Application by Highways England for the A303 Sparkford to Ilchester Dualling project
The Examining Authority's written questions and requests for information (ExQ1)
Issued on 20 December 2018

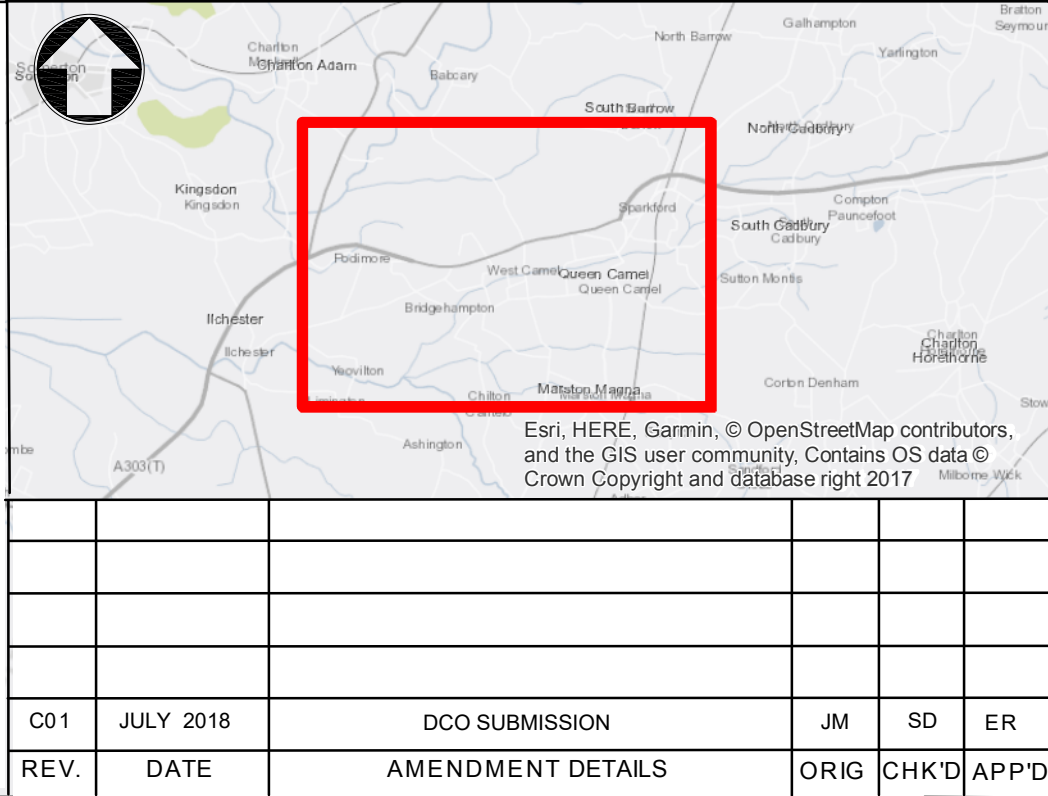
1.4.11.	The Applicant	Clarification The operational study area depicted in Figure 11.1 in Chapter 11 of the ES [APP-048] is inconsistent with the operational study area described in Chapter 11 section 11.6. Can this be rectified please?
